Your Ref :
Our Ref : P/91/17/NMA

Application for a non- material amendment following the grant of P/125/14/PL relating to approved plans.

251 Pagham Road, Pagham, ,

FOR
CRAYFERN HOMES LIMITED
Scale : 1:100 @ A1 Date : AUG 17
Drawing No : 108_16 SK07

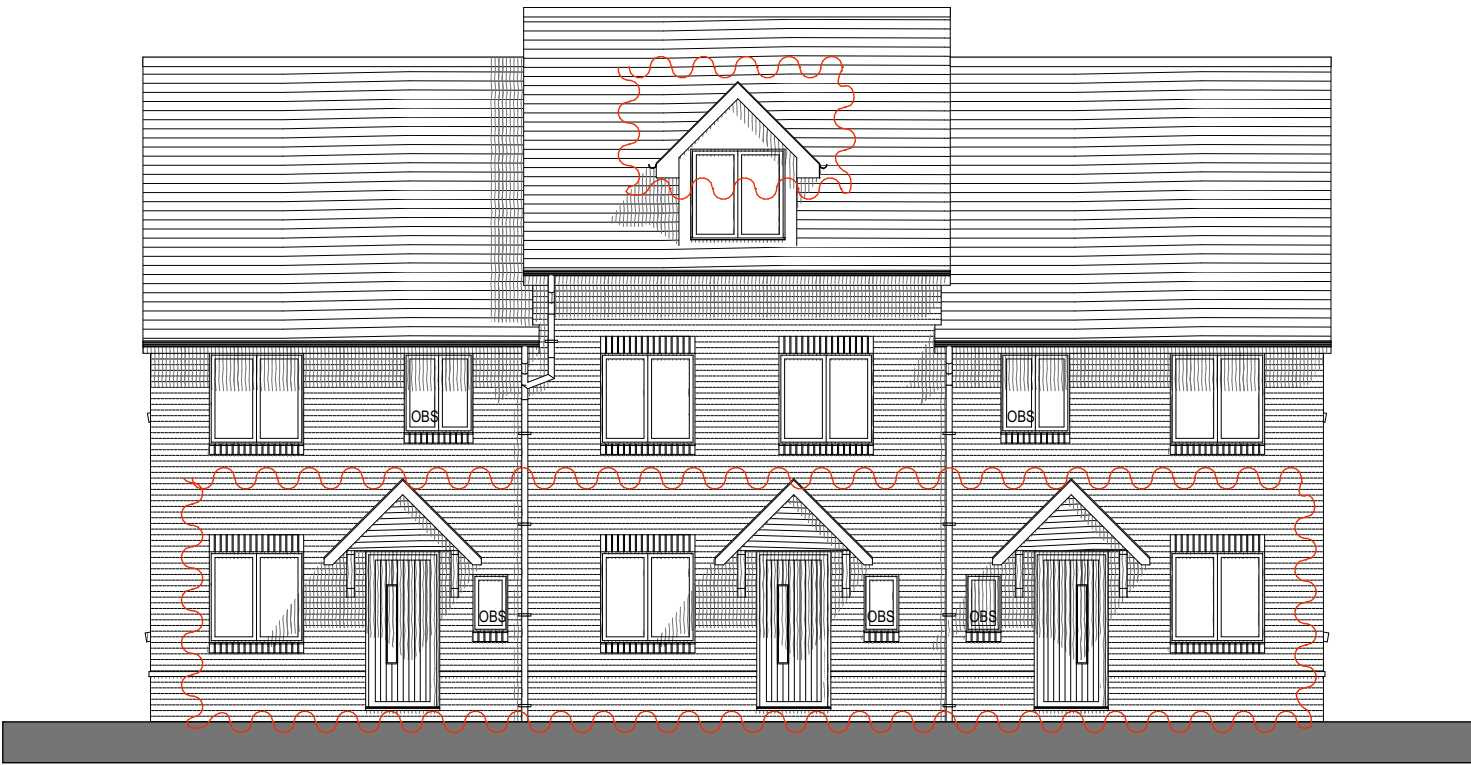
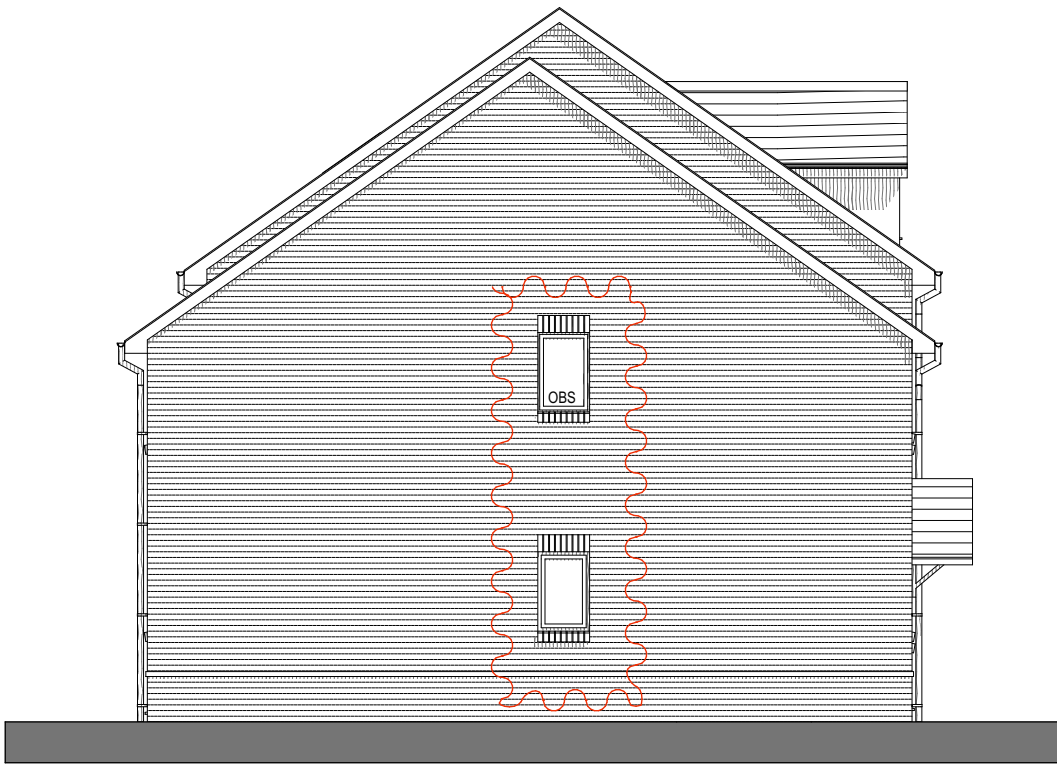
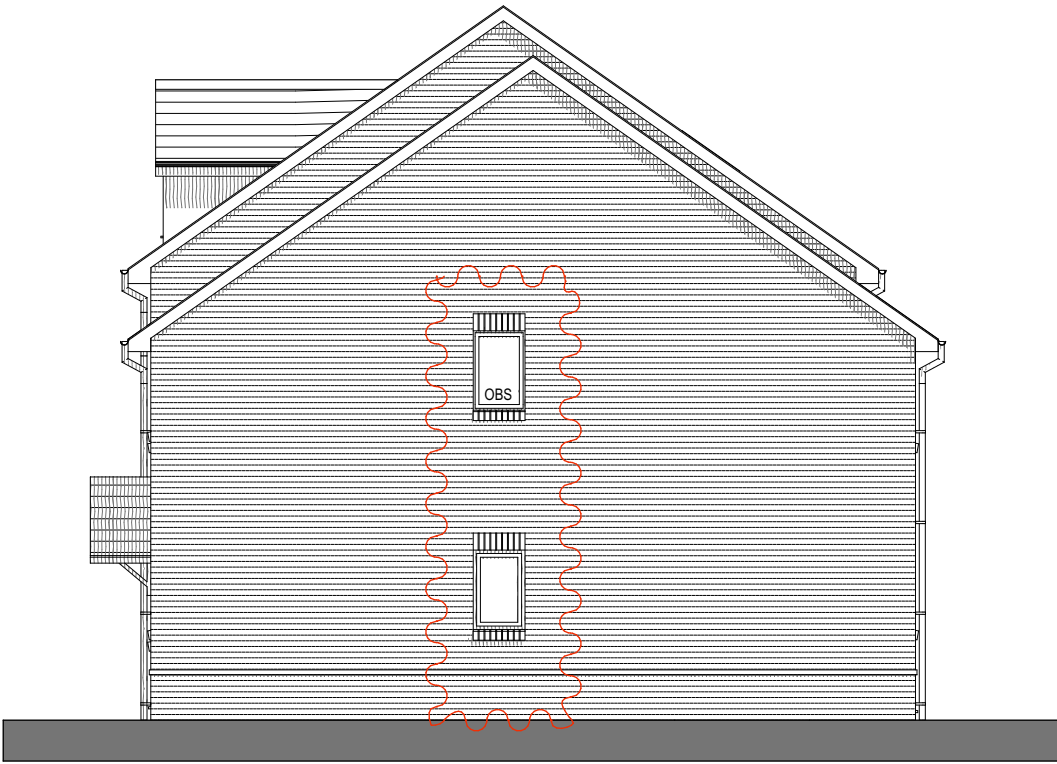
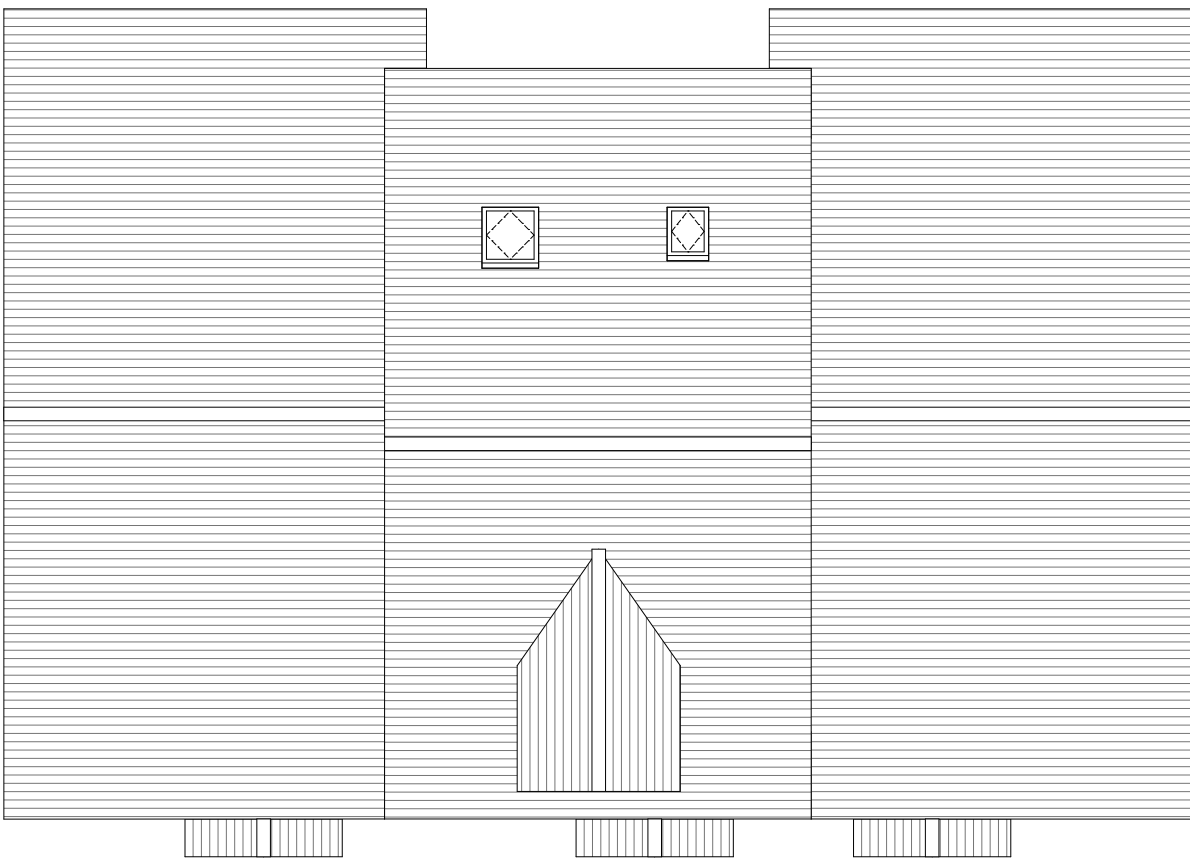
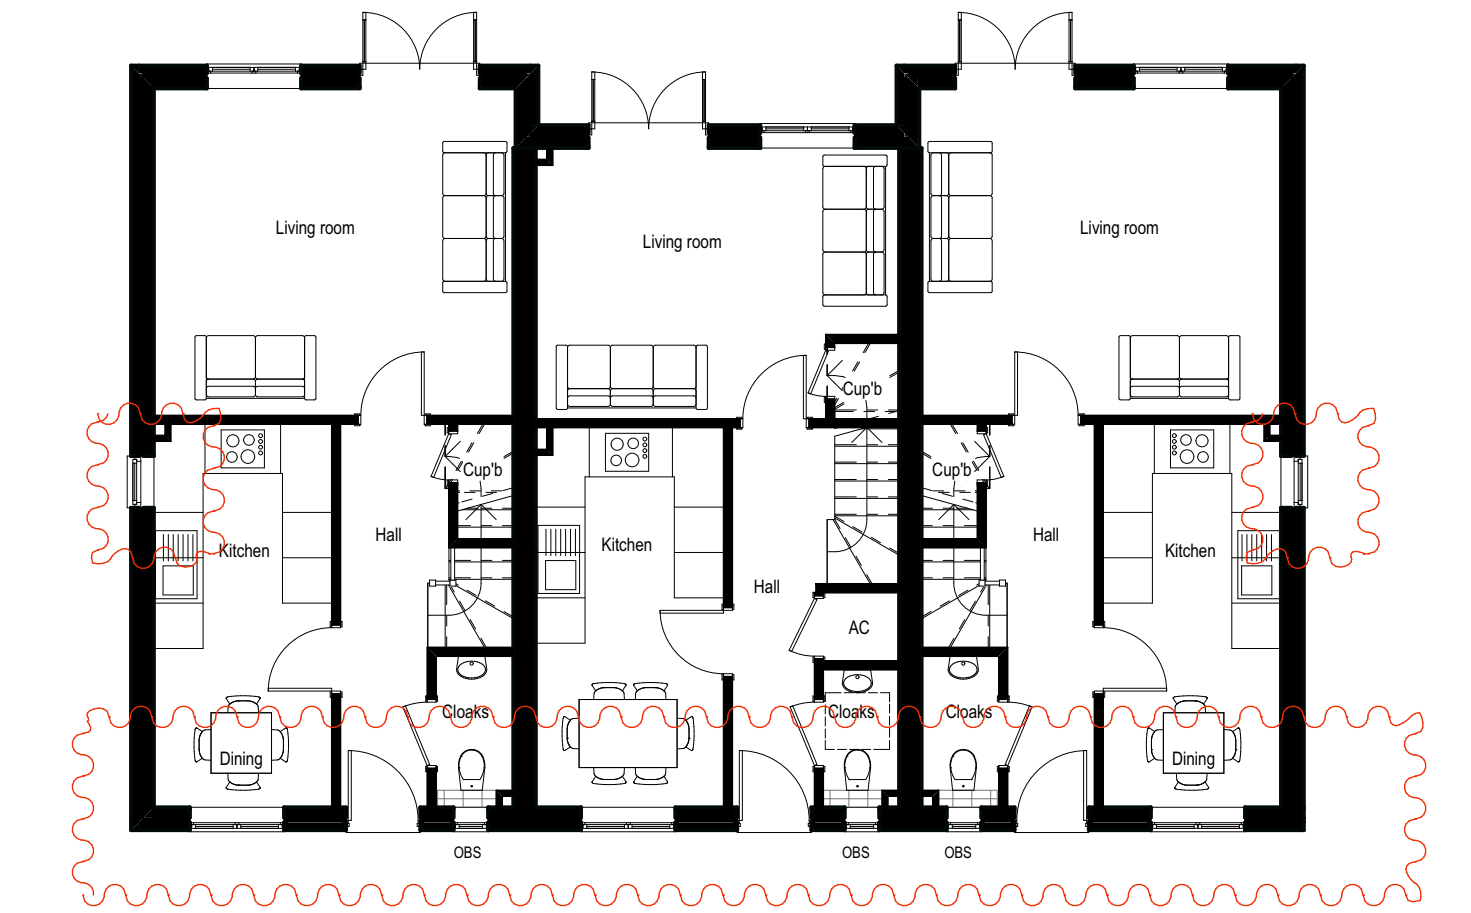
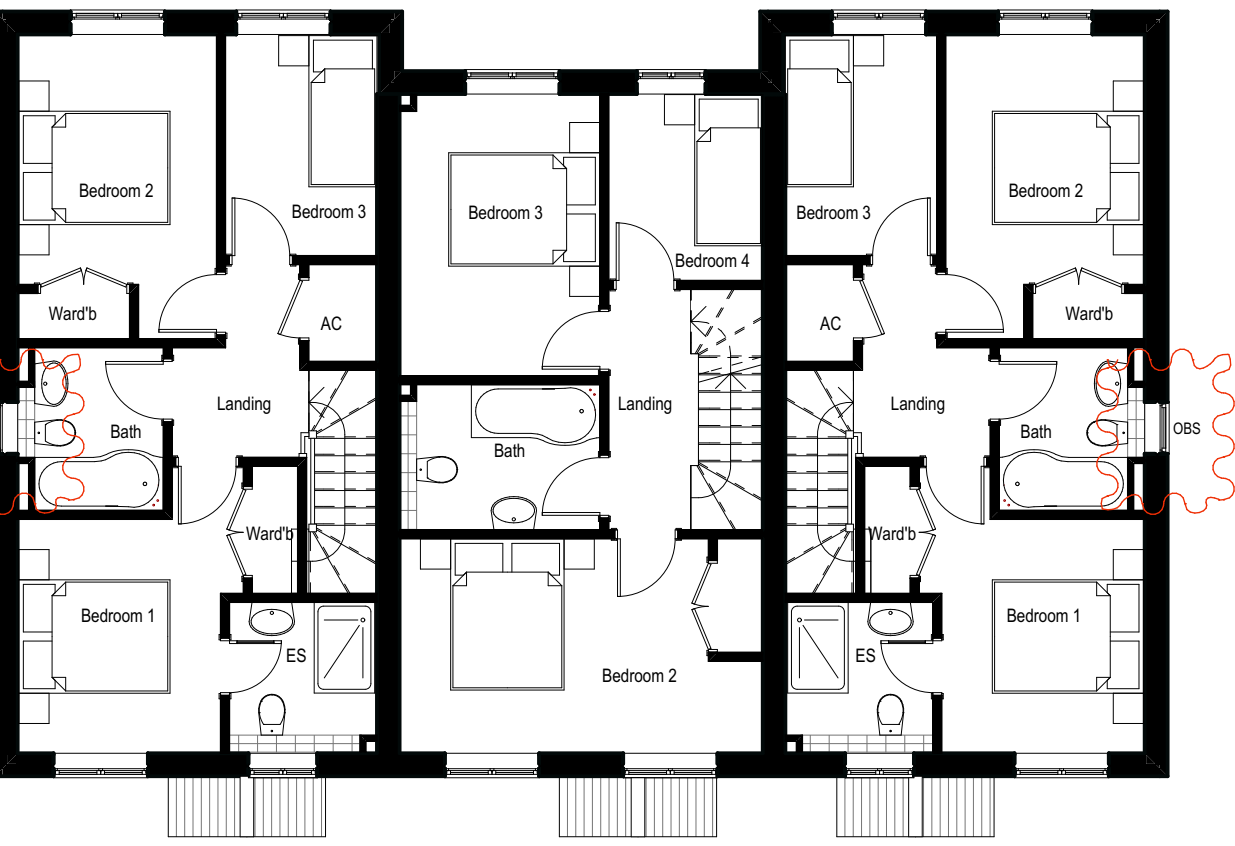
Plots 15-17 - Alterations to the design of first floor rear windows, alterations to the design of the ground & first floor windows to both side elevations, alterations to the design of the ground floor front windows & doors and alterations to the design of the roof level front single dormer;

FOR
CRAYFERN HOMES LIMITED
Scale : 1:100 @ A1 Date : AUG 17
Drawing No : 108_16 SK11

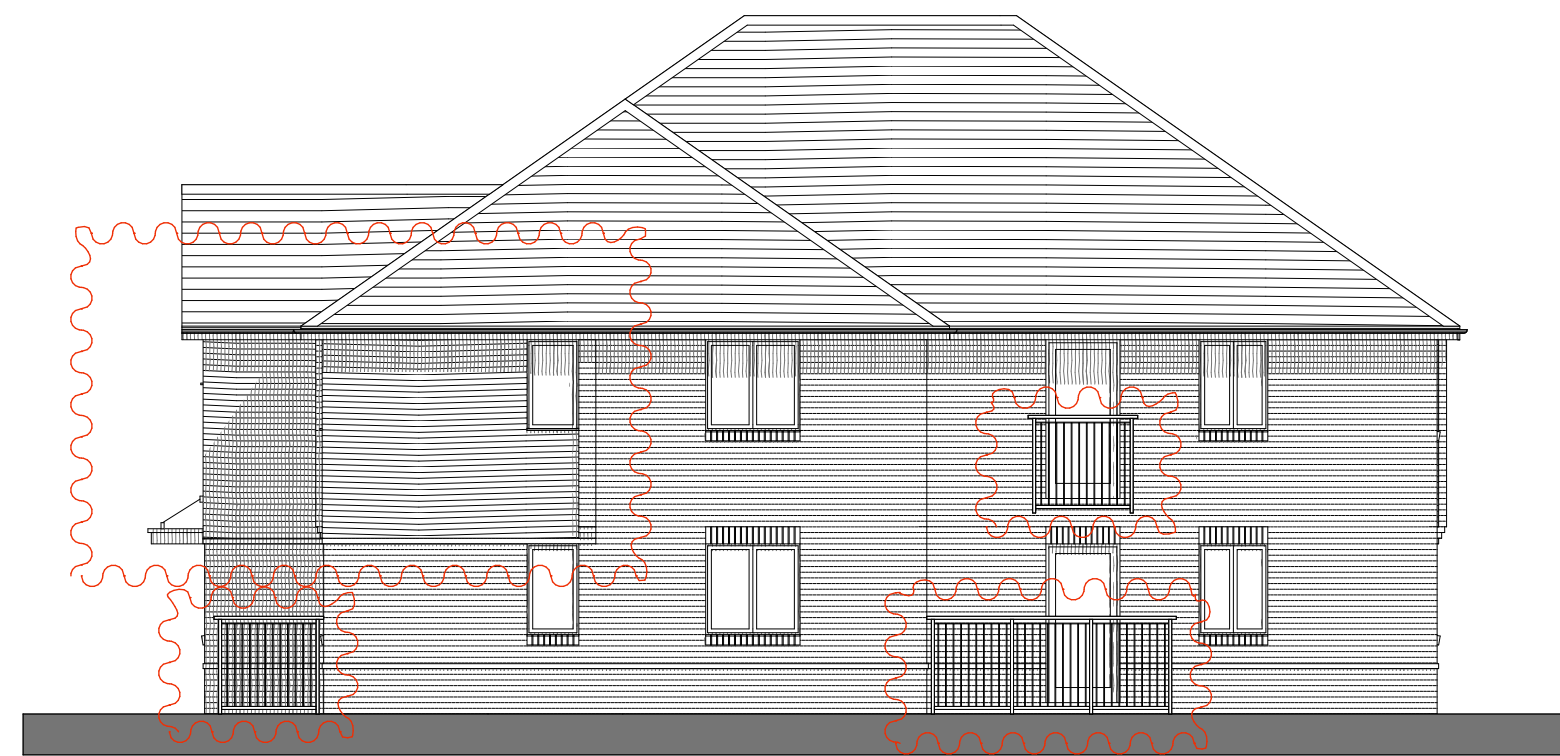
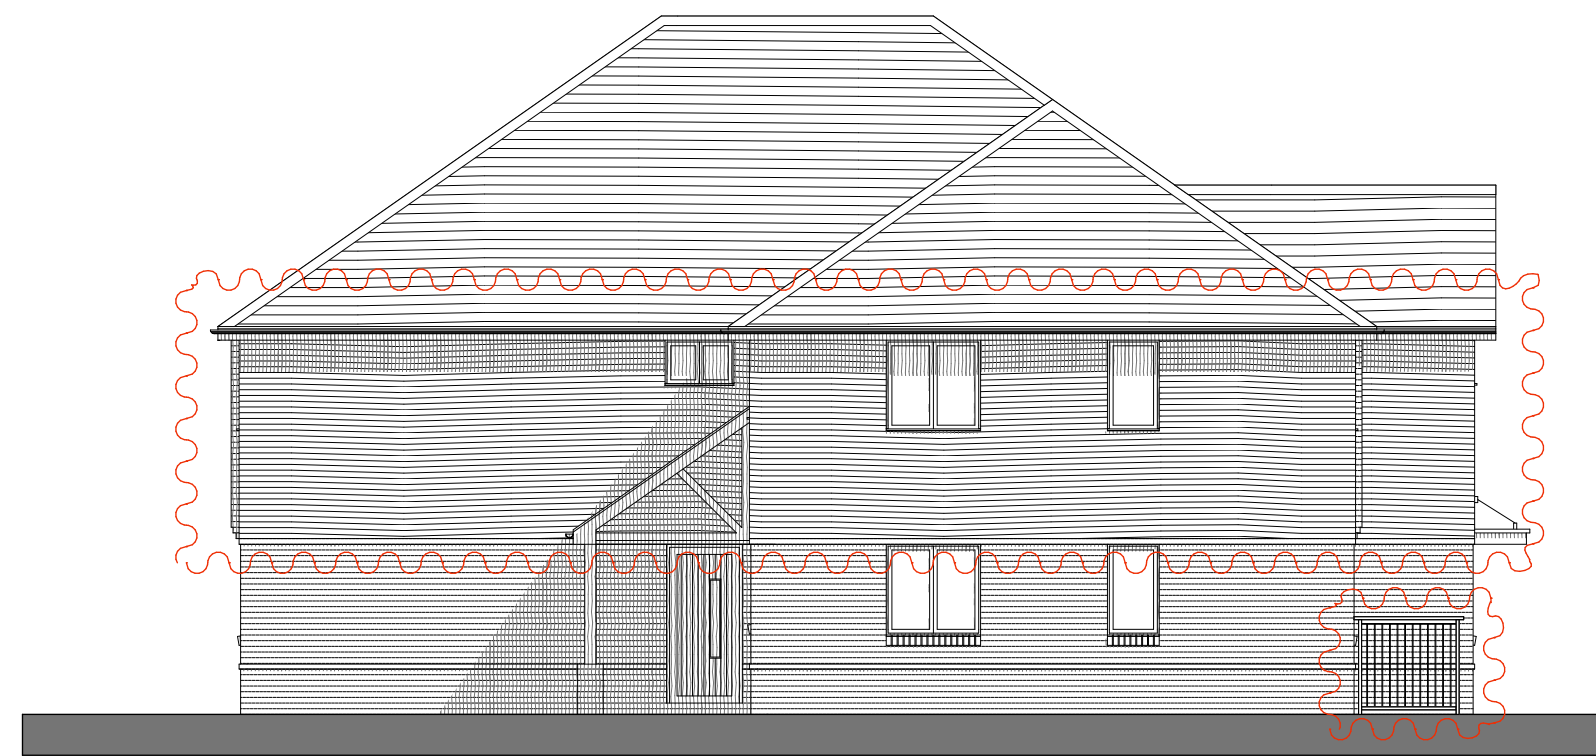
Plots 22-27 (Flats) - Materials changed from brick & cladding to all brick, removal of first floor useable balconies & replacement with Juliette balconies;

It is regrettable that the decision has been taken to remove the balconies to the first floor flats as these were proposed following planning officer negotiation on the original application in order to provide a better standard of amenity for first floor occupiers. However, they are nonetheless acceptable as non-material amendments.
